March 4, 2022

RE: Meadoworks Development Plan and Final Plat – 2nd Review Comments
City File # AR DP 21-00591, AR FP 21-00592, AR FP 21-00593, AR FP 21-00594, AR FP 21-00595

In response to the updated March 1, 2022 Review Comments in regards to the Meadoworks Development Plan and Final Plat we have provided the below responses in red and associated revised drawings.

COVER SHEET

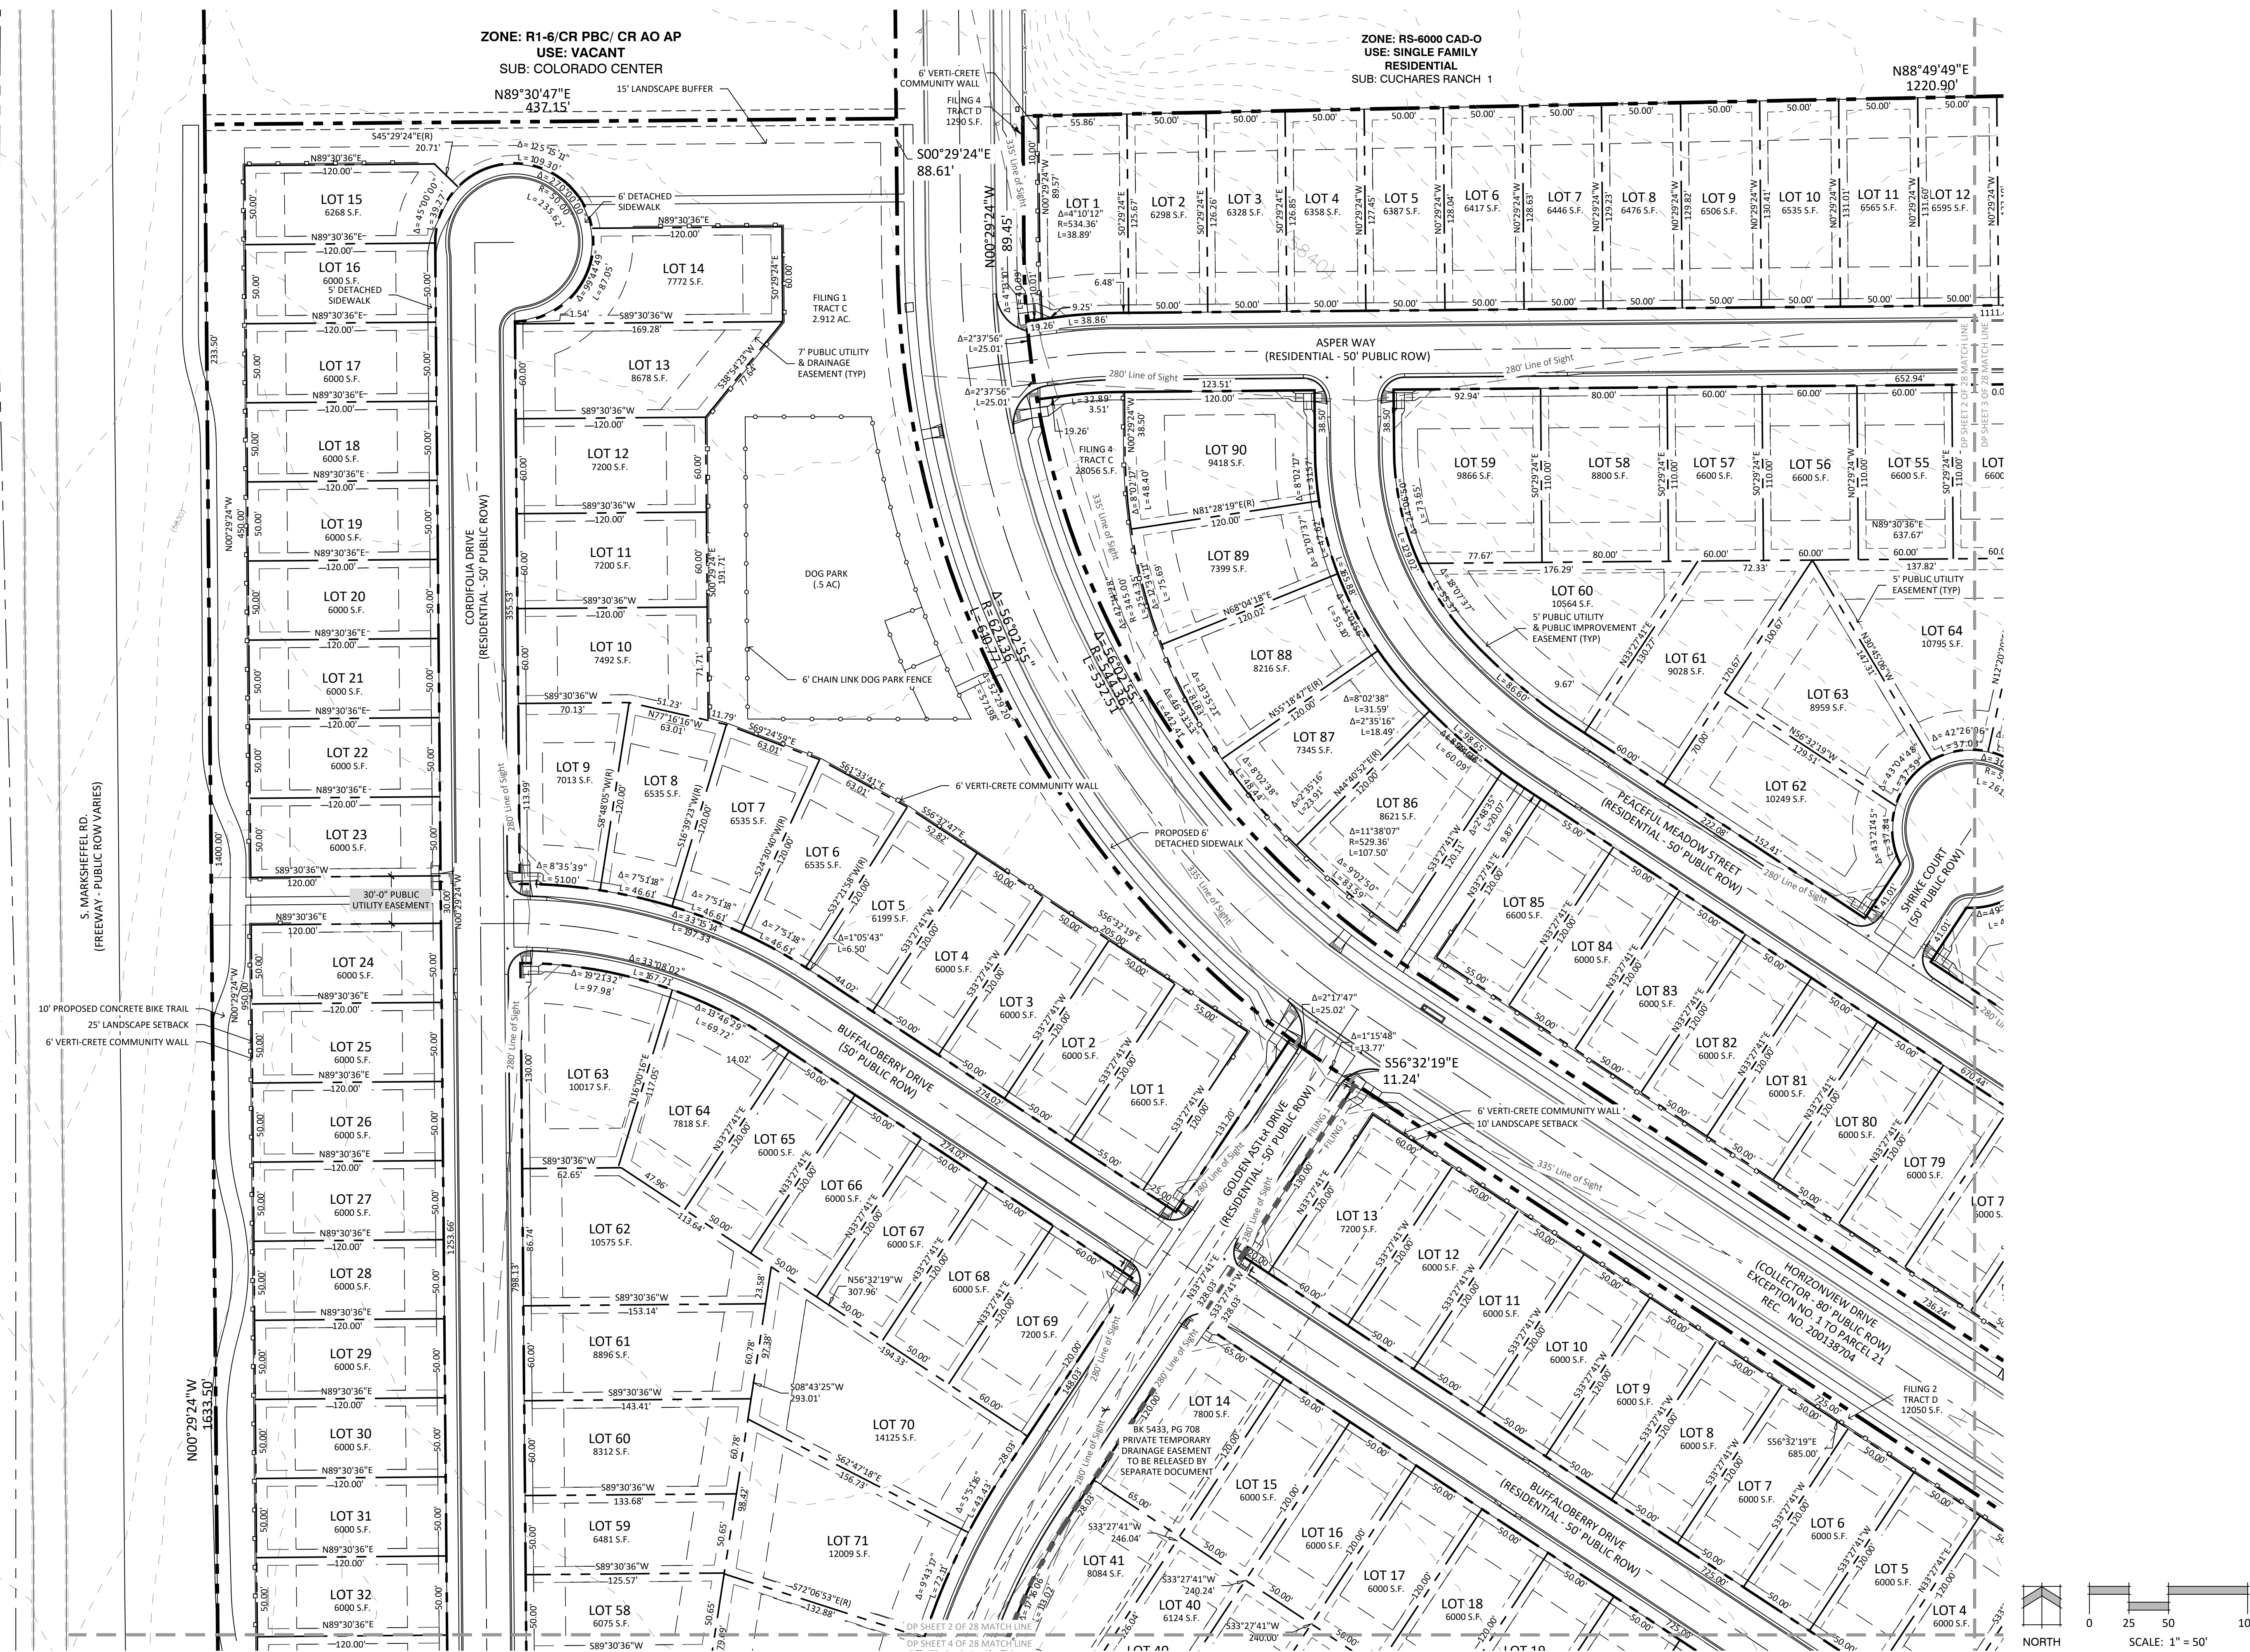
1. Not Addressed Sheet 1: The floodplain statement lists the FEMA flood zone as Zone AE, but also states that no portion of the site is within a designated FEMA floodplain. Zone AE refers to areas where base flood elevations have been determined. Please reconcile. If the platted area is within a designated FEMA flood hazard area, the 100-year floodplain line should be shown. (FEMA statement still reads "No portion of the site, Meadowworks Filing No.1")
The FEMA general note on the cover page does not reference Zone AE and matches the plat.

DEVELOPMENT PLAN

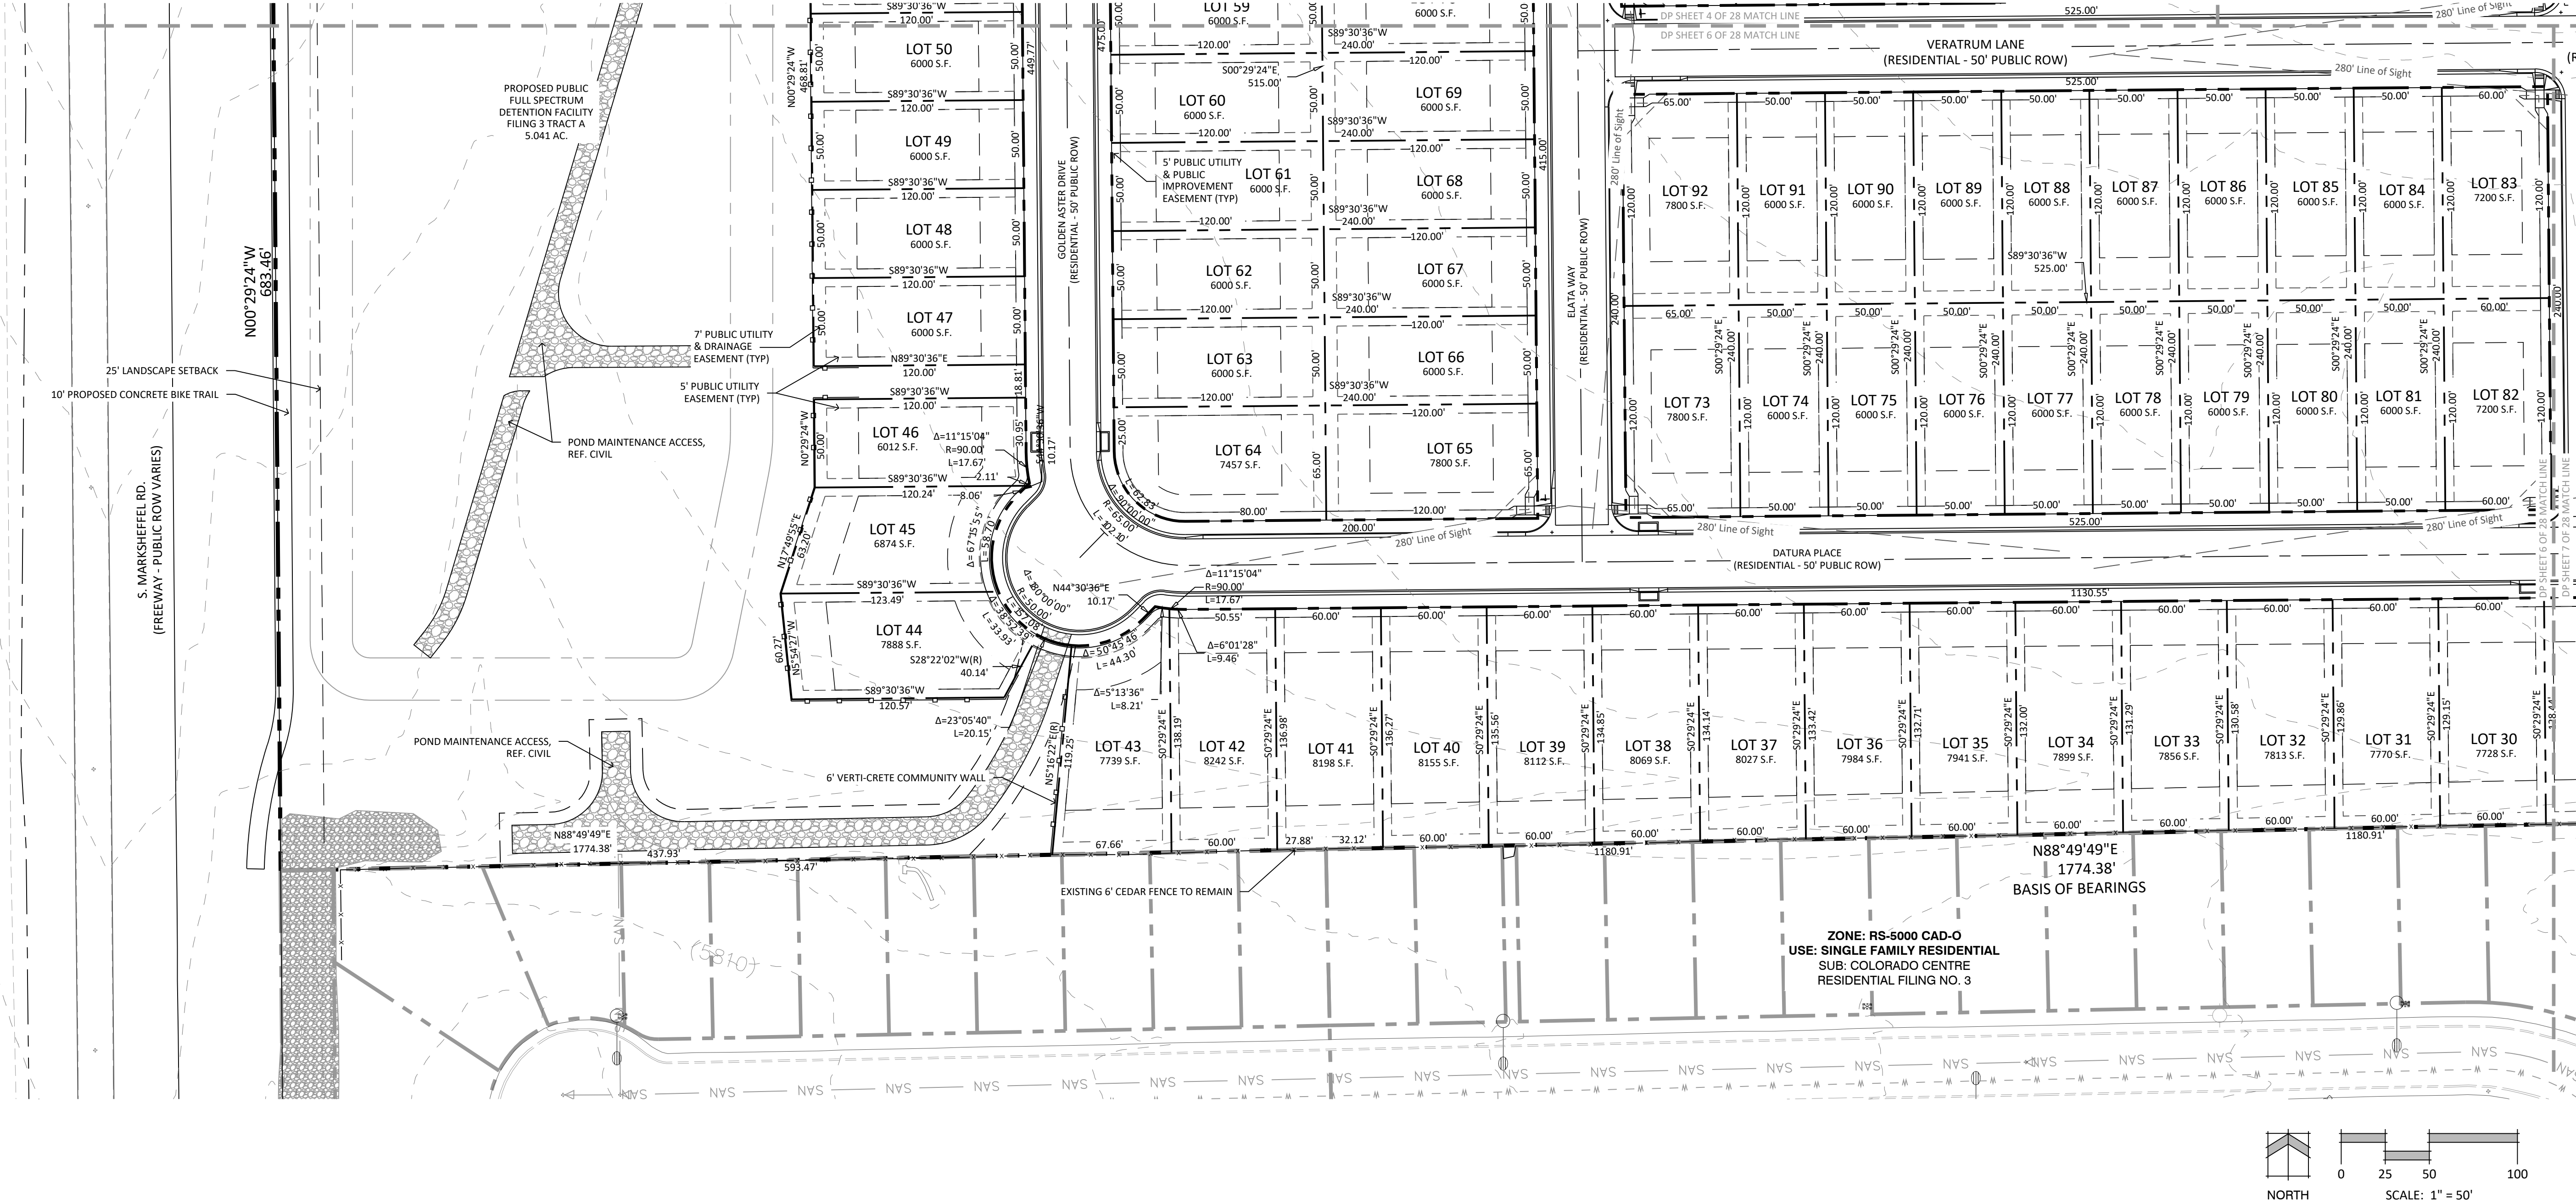
2. Not Addressed Sheet 4,6, 10,12, 16, 18, 26: Clearly label the maintenance access to the proposed EDB on all applicable sheets, including Landscape Plans. Ensure maintenance access meets criteria (refer to DCM volume 1, chapter 13, section 5.16 for maintenance access requirements). Sheet 6, 16, 18, 26, are missing access road label.
Pond maintenance access has been called out on all applicable sheets.

DESIGNED BY	KRC	SCALE	DATE	09/03/21
DRAWN BY	LDB	(H) 1"= 50'	SHEET	16 OF 28
CHECKED BY		(V) 1"= N/A	JOB NO.	2506.00

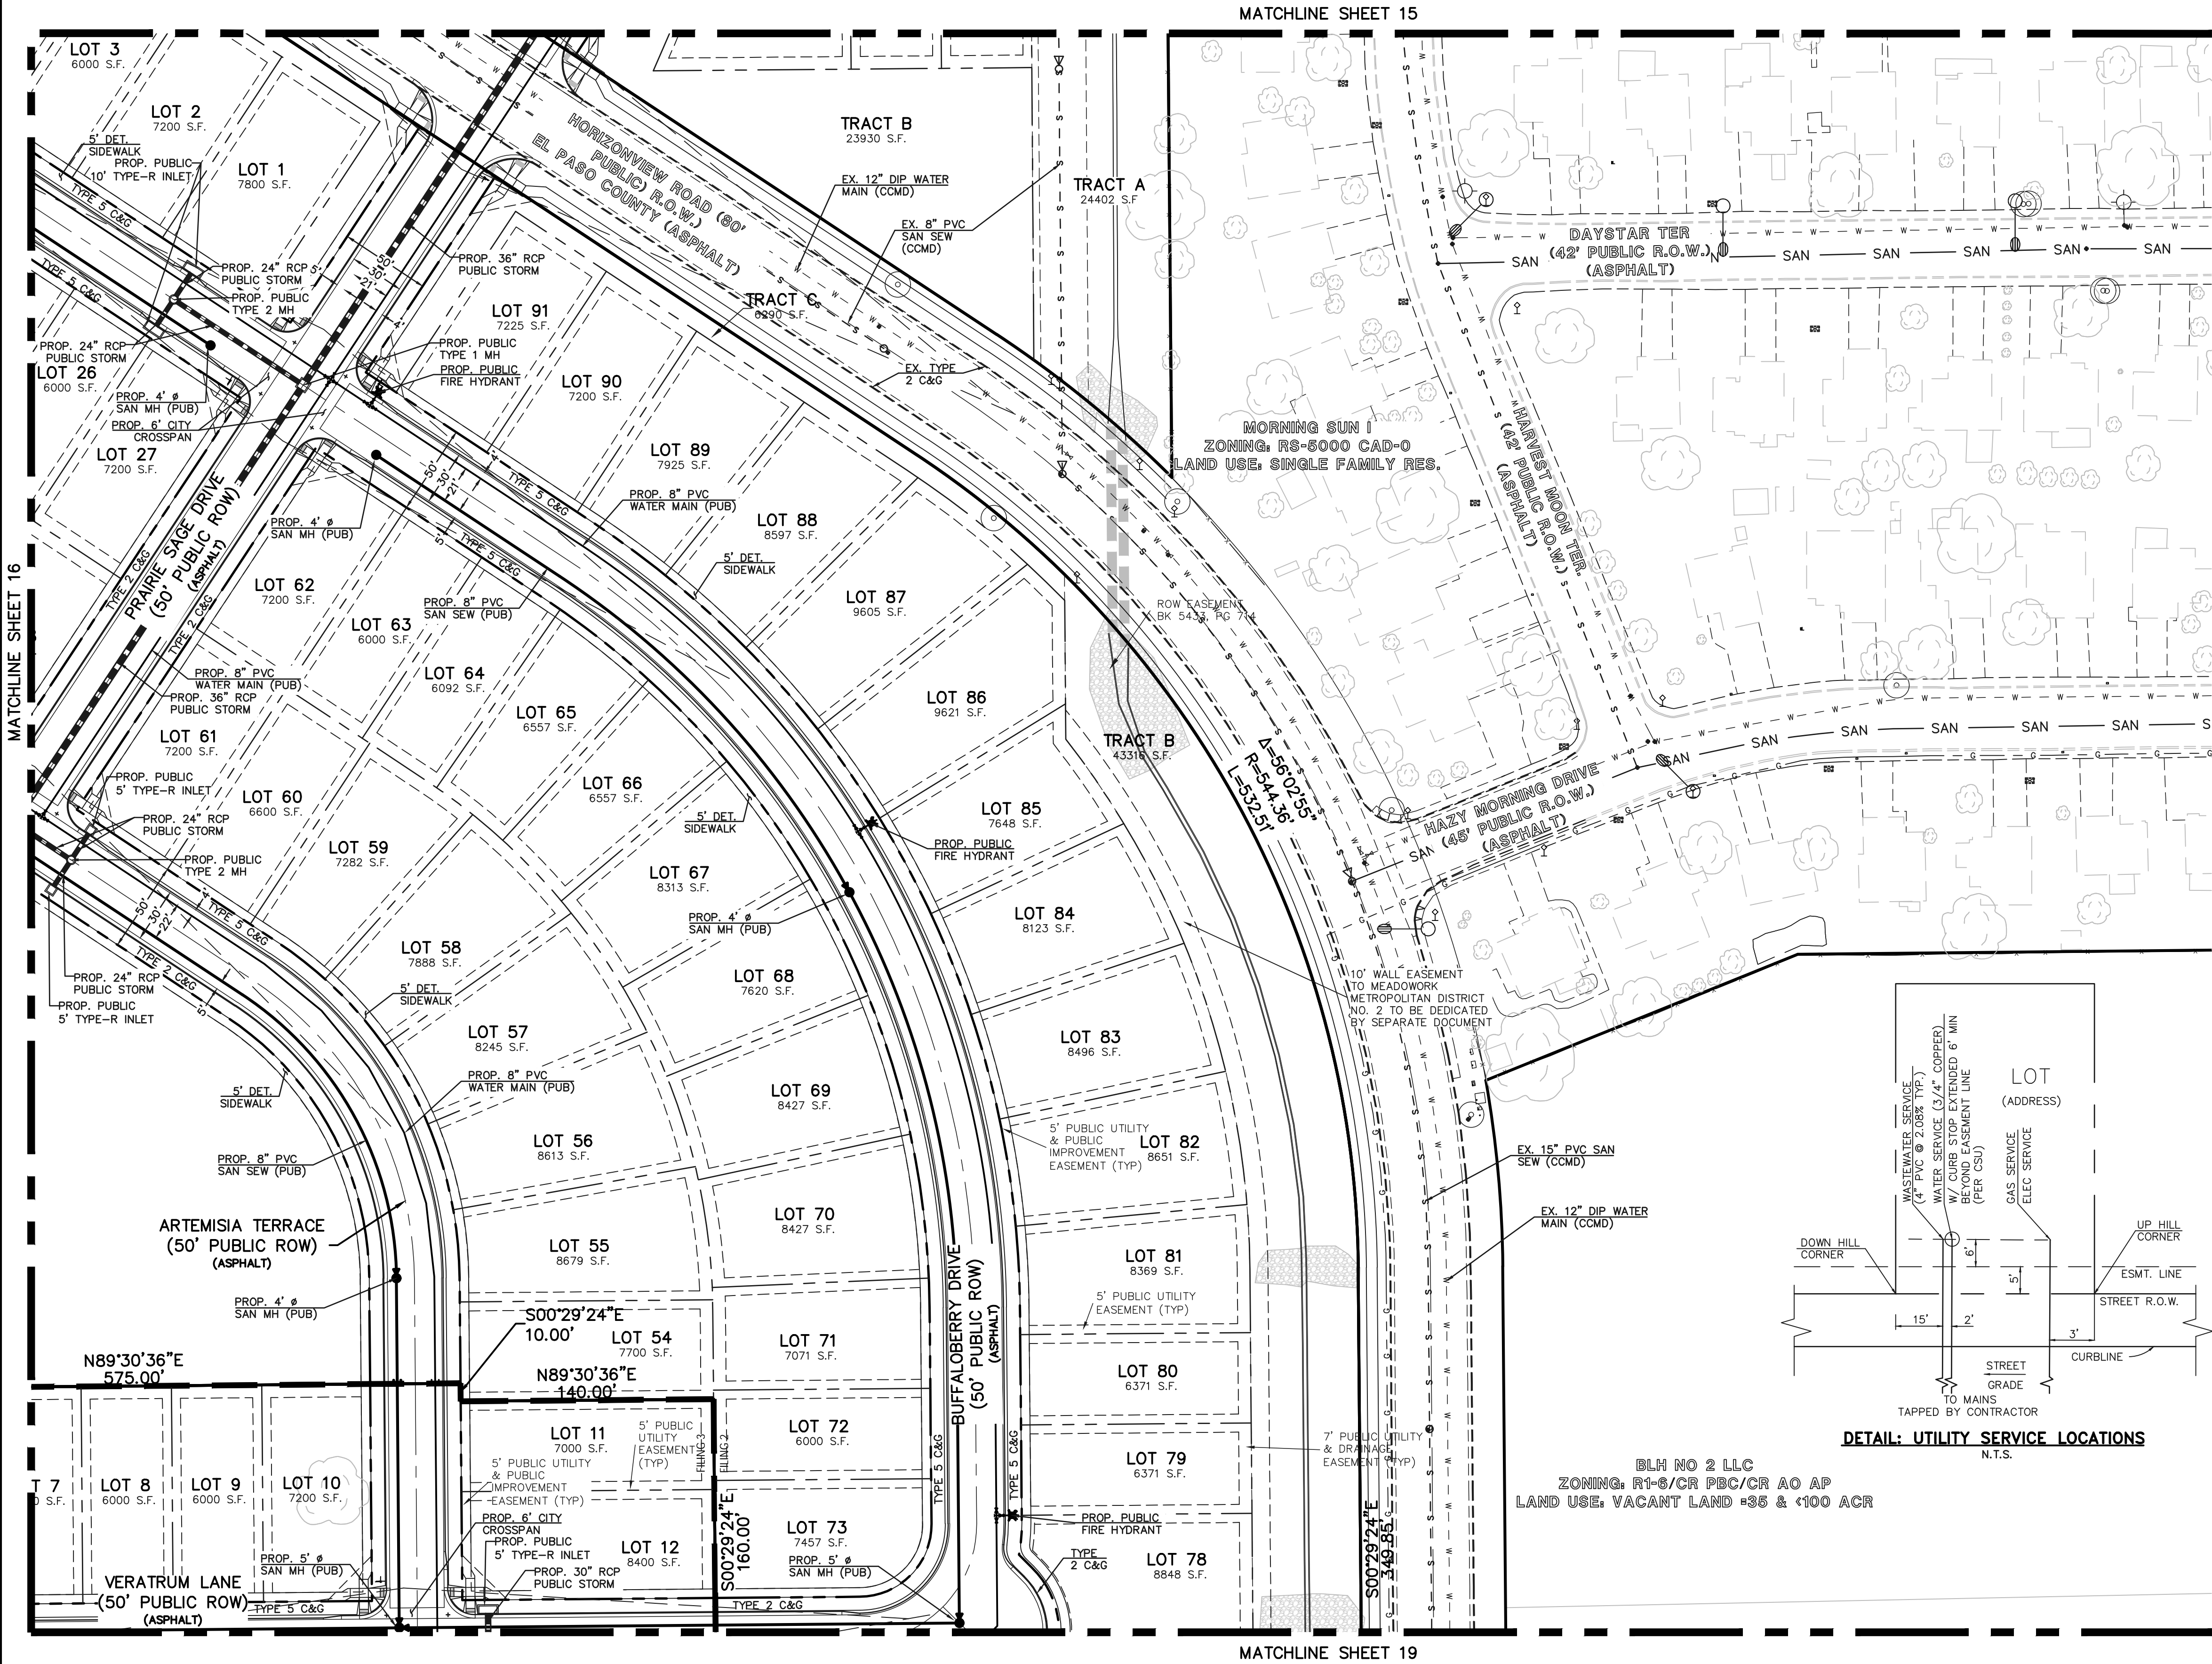
3. Not Addressed Sheet 14-19: Label all proposed drainage facilities with size, type, material, and private or public.
Labels have been provided on all applicable sheets.
